Department of Planning and Environment
4 Parramatta Square, 12 Darcy Street
Parramatta NSW 2124

**COUNCIL SUBMISSION
NOTICE OF EXHIBITION OF MODIFICATION REPORT NO. 1 FOR THE PARRAMATTA
POWERHOUSE (30B PHILLIP ST, PARRAMATTA)**

I refer to the above application and the request to provide advice on the proponent's modification report to the St Georges Terraces and eastern rooftop. Council has reviewed the supplied report and wish to make the following comments:

1 PROPOSED ELEVATION S  
1 : 100

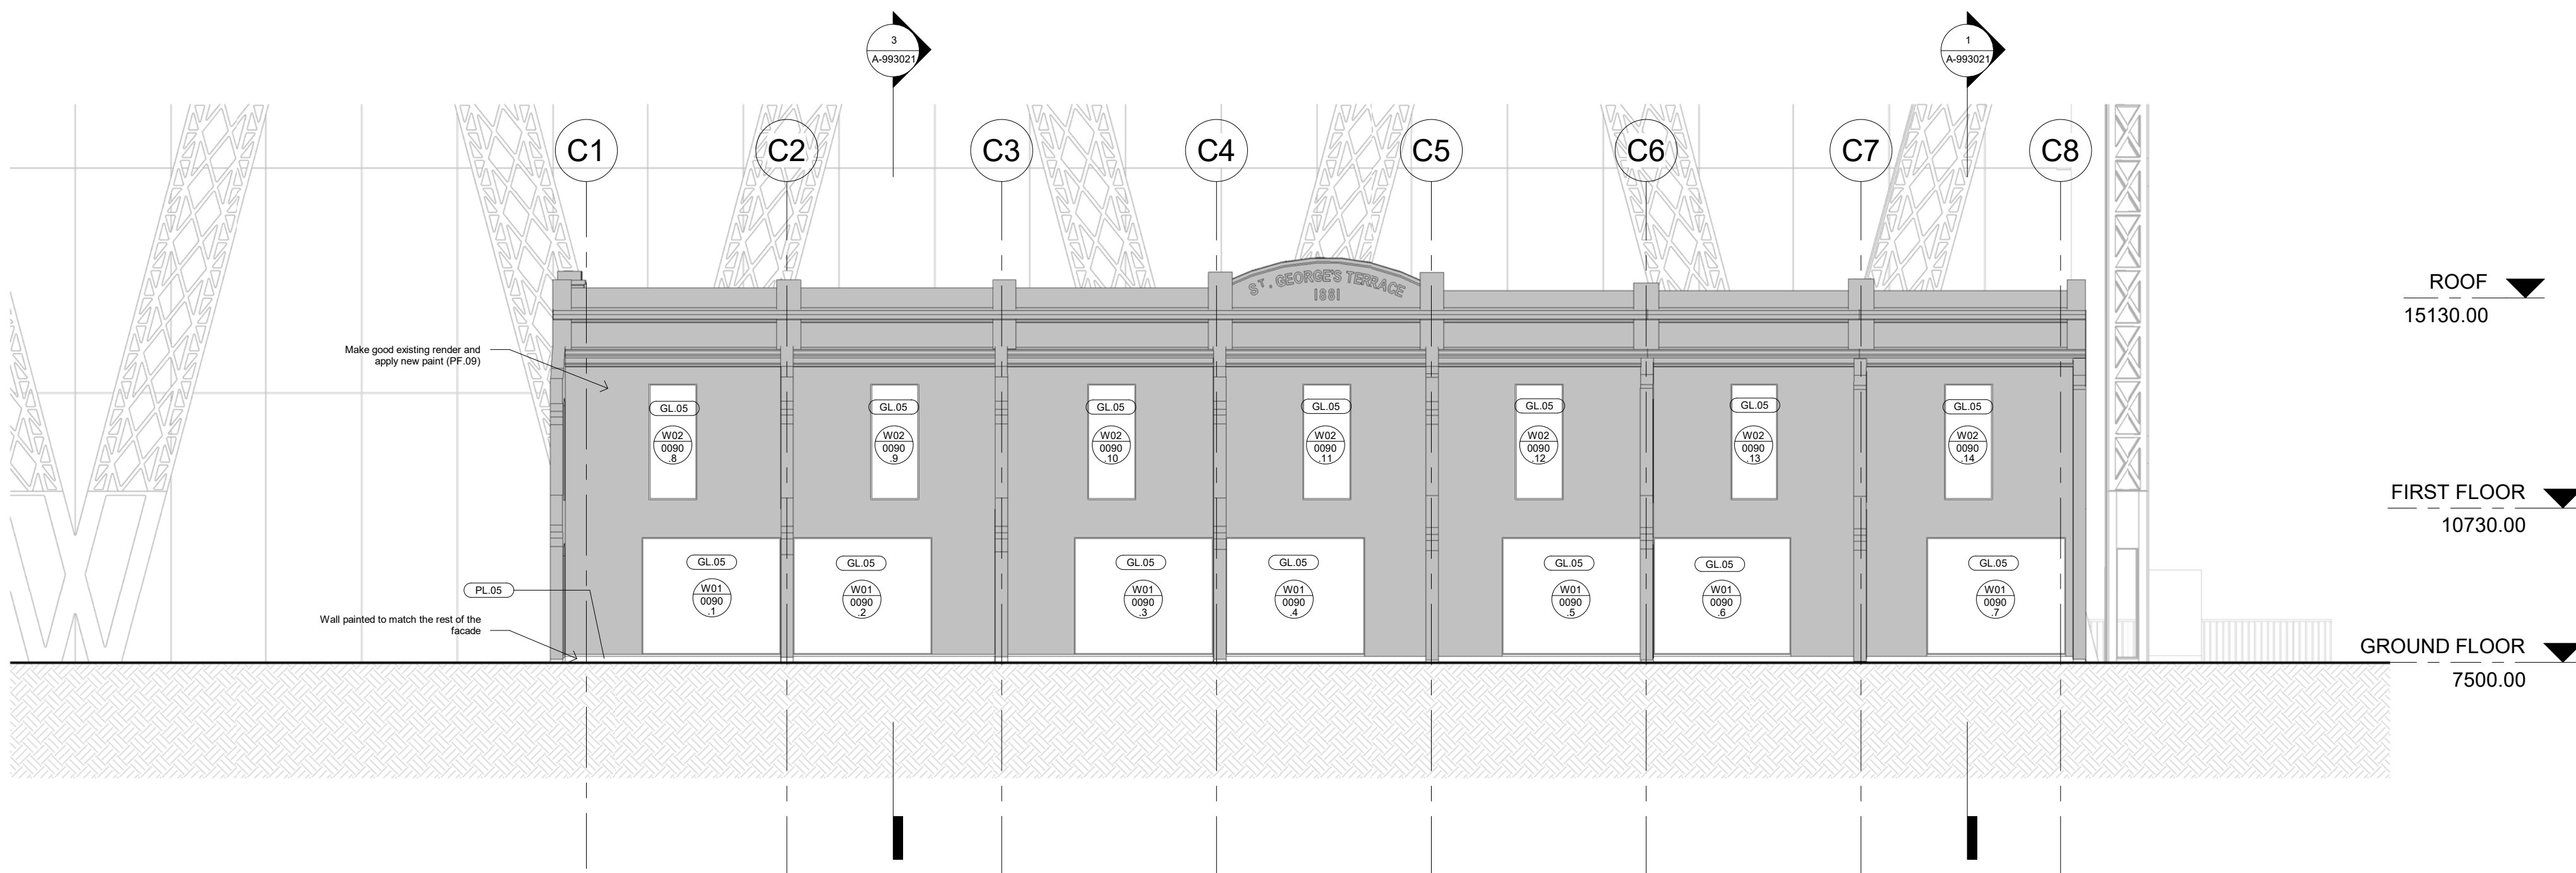
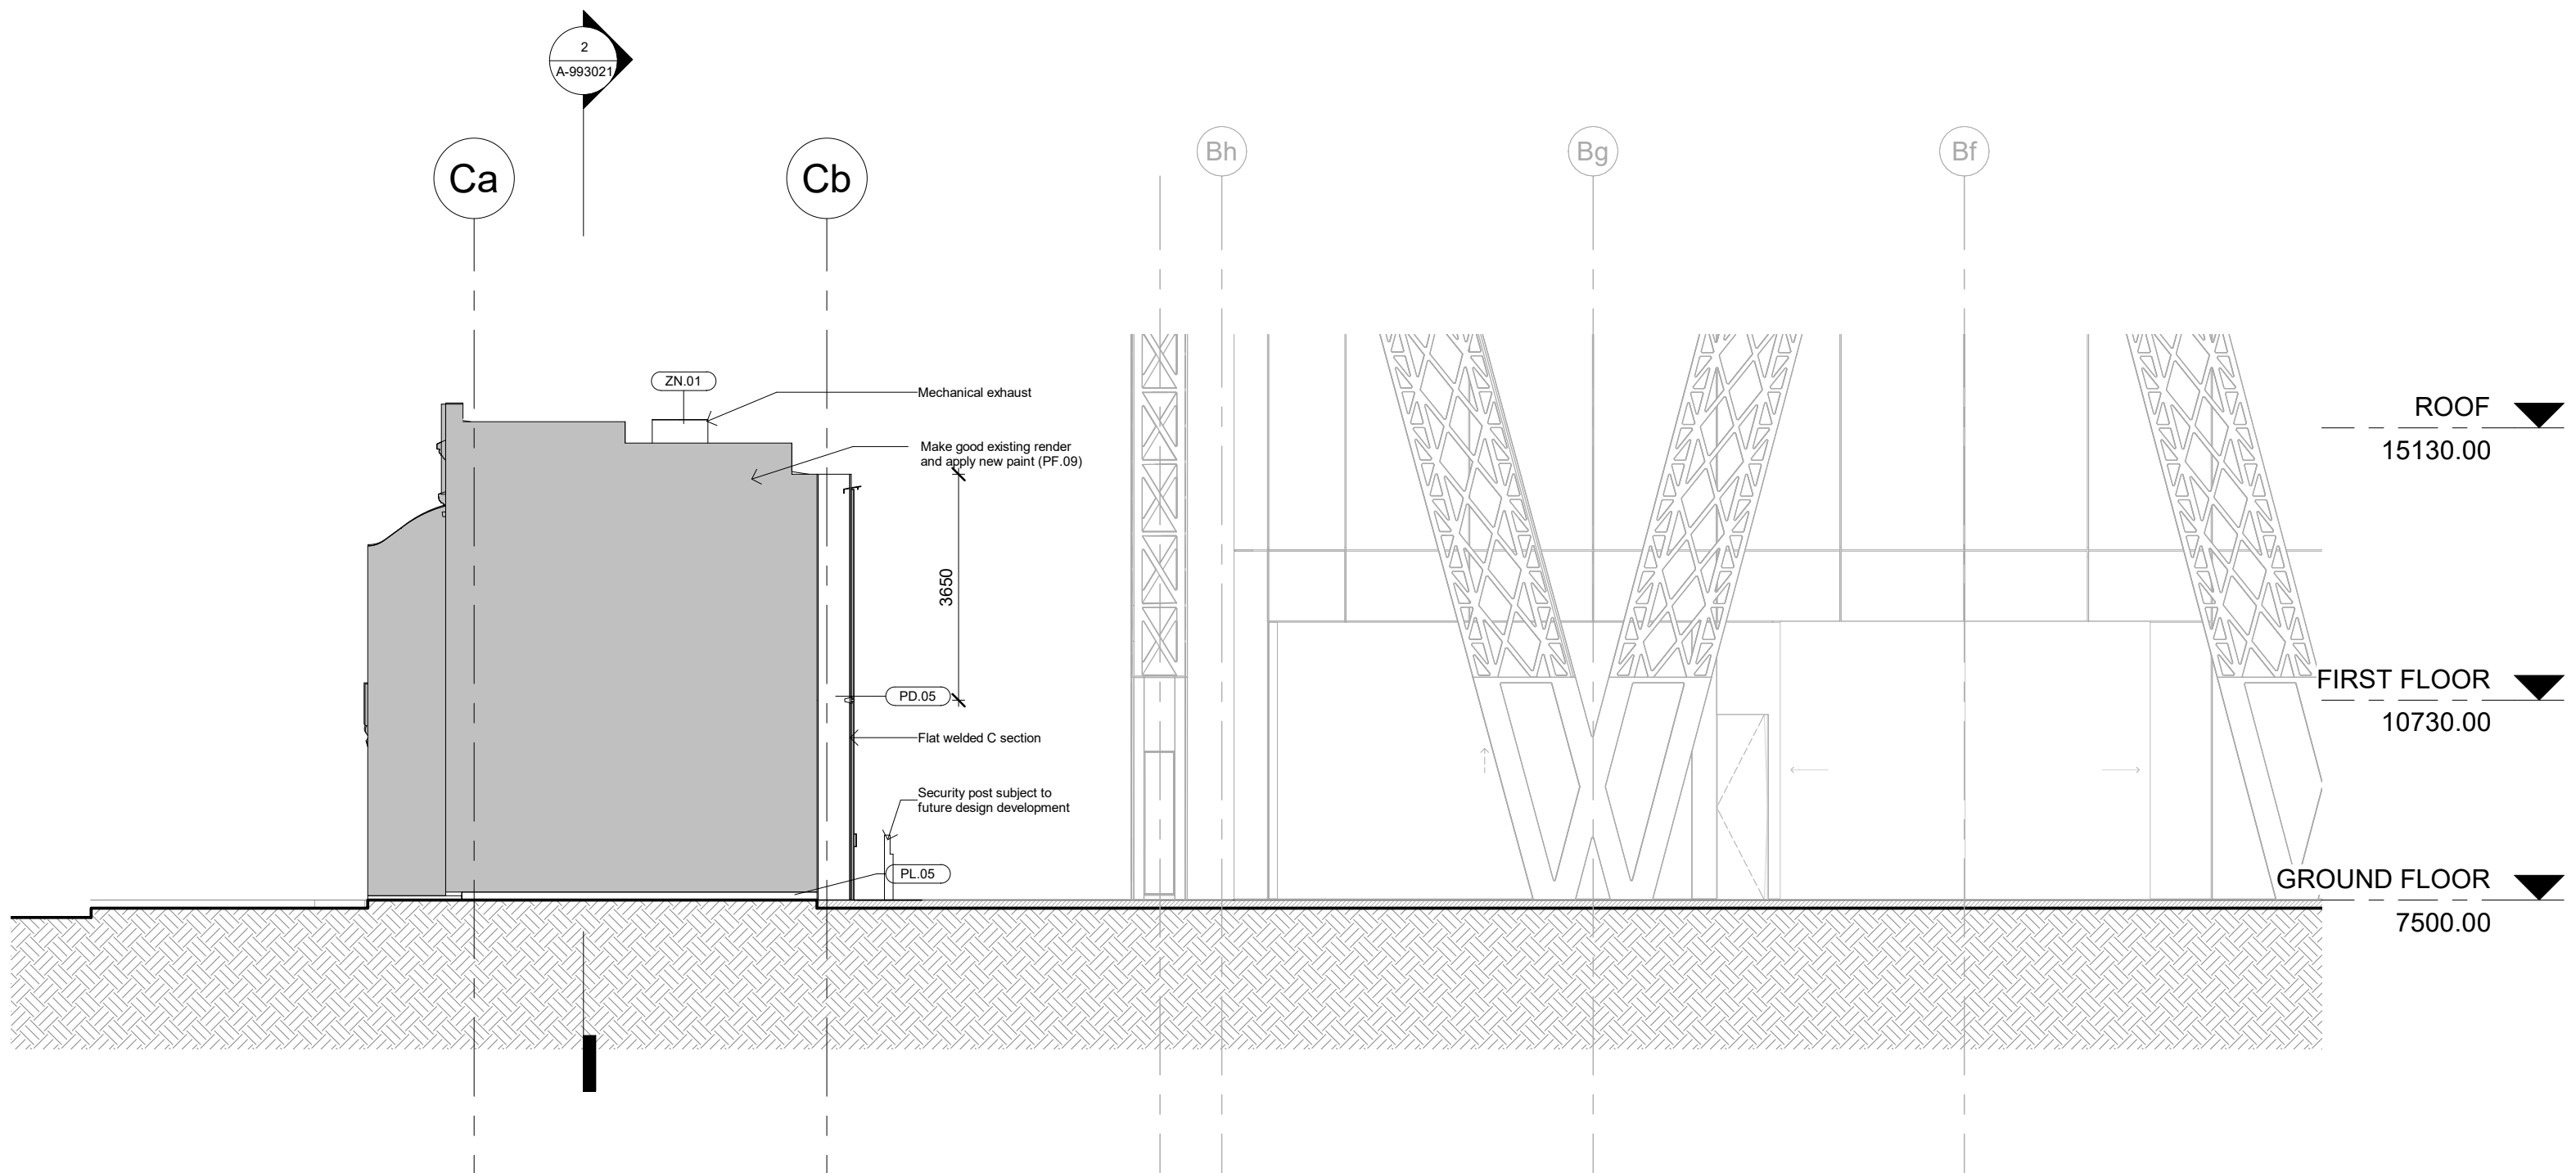
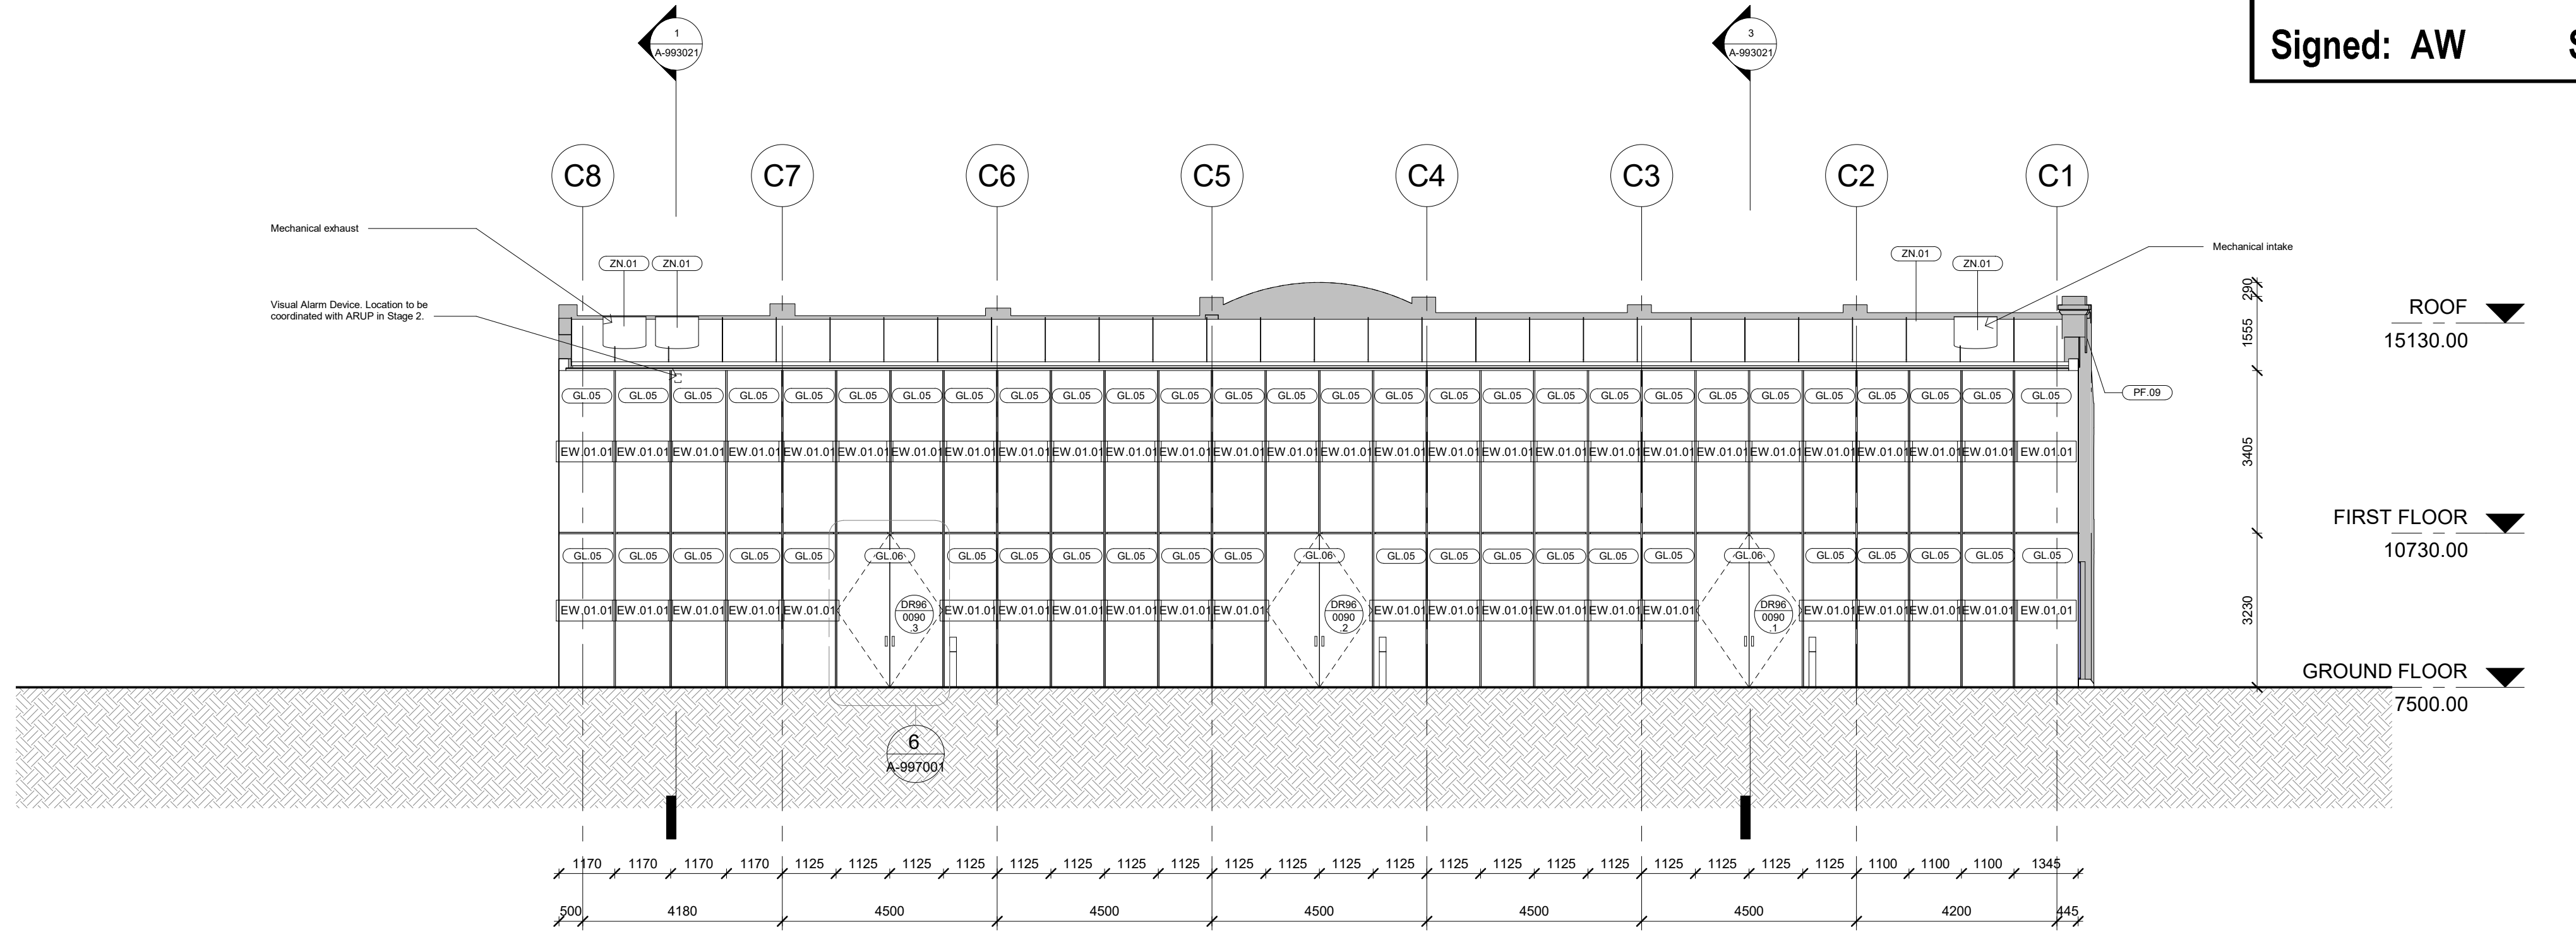
2. The window and door openings should be reinstated to the original proportions, including the removal of the brick window infills.
3. Fill or reconstruct the additional opening spaces at ground level that were created to convert each terrace into a commercial business with shop front incorporating door (between 1970 and 1978). This should be based on historical evidence if any and the use of sympathetic materials compatible with the building's heritage value is recommended.

roofs cast iron balustrading, and plaster urns that surmounted the continuous parapet that have all been removed". However, research of historical evidence and comparative analysis could identify suitable examples to be adopted for the reconstruction. These verandahs could be supported via an internal walkway to support the maintenance.

7. Reinstatement and redesign of front door and windows inspired and based on typical Victorian style doors and windows. This could form part of the heritage interpretation.

8. Removal of intrusive 1970 addition of verandahs aluminium awning, rods, signage and brackets on each terrace.
9. Reinstatement the verandah floors at ground level that were brick paved in 1970, based on historical evidence if any, and HNSW guidelines, this could be part of the heritage interpretation.
